Please ask for: Nicola Moore
Email: nicola.moore@arun.gov.uk
Telephone: Ext 37944
Our Ref: BN/48/21/CLP
Your Ref:
Date: 26th April 2021

Lawful Development Certificate for a Proposed Use or Development

Development: Lawful development certificate for a proposed garden room with garden store attached.

Location: Pippin Cottage, Highgrounds Orchard Highground Lane Barnham PO22 0BT

Pippin Cottage

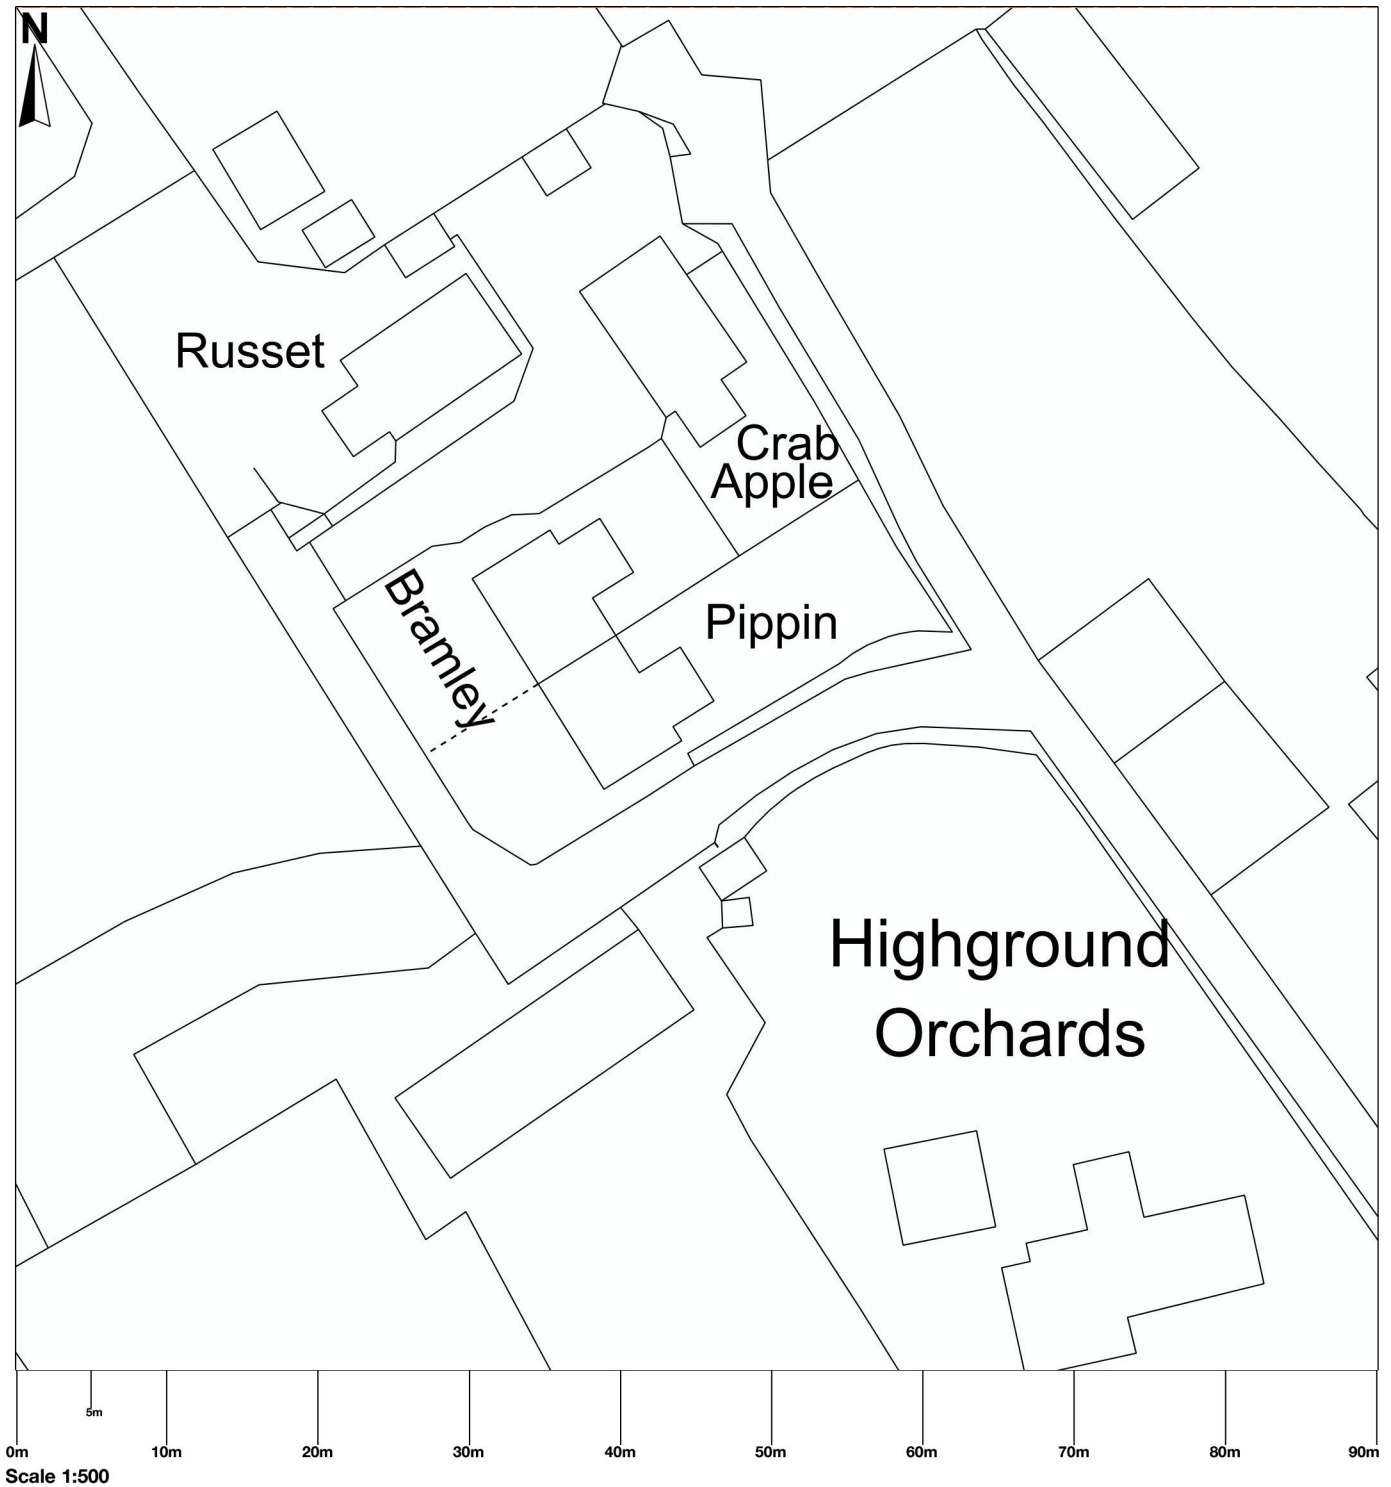
Block Plan

Please provide the measurements to boundaries. The measurements of the proposed building do not match those on application form. Please check, amend accordingly and re submit.

NOT TO SCALE

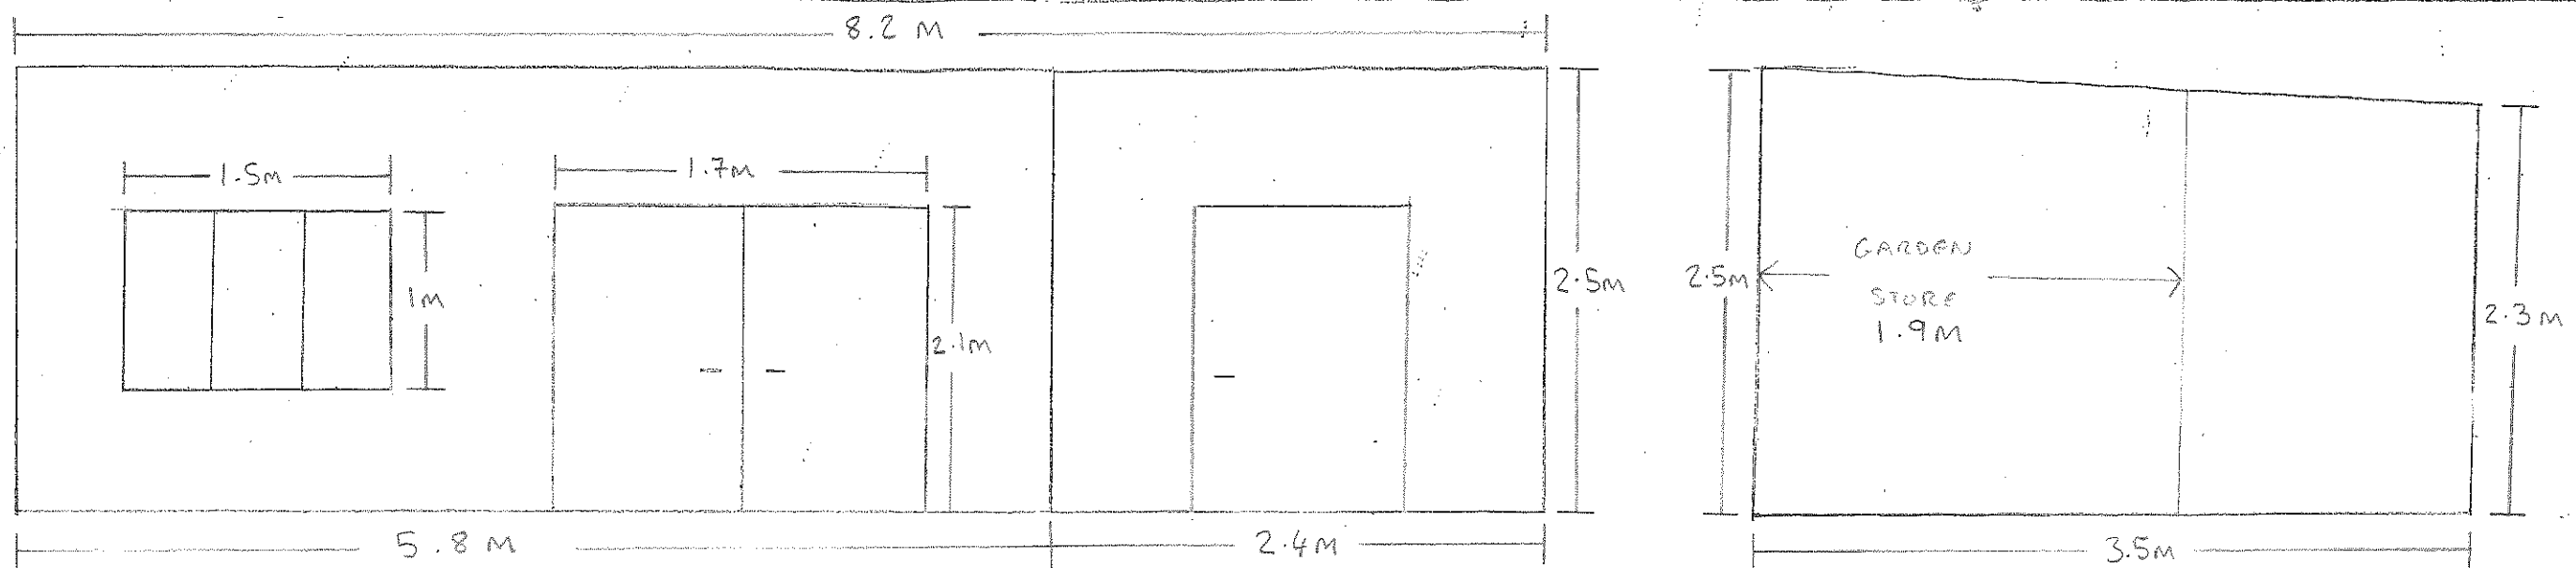
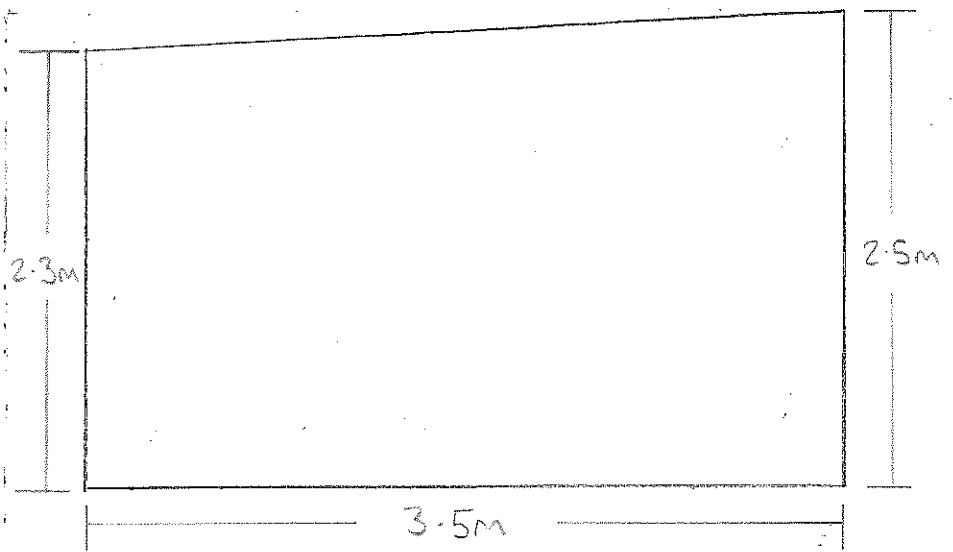
Elevations

We are unable to scale plans at 1:40, please either remove the scale and add clear dimensions, or scale at 1:50 or 1:100.

Please clarify if the sky light window in roof is to be included in the description.
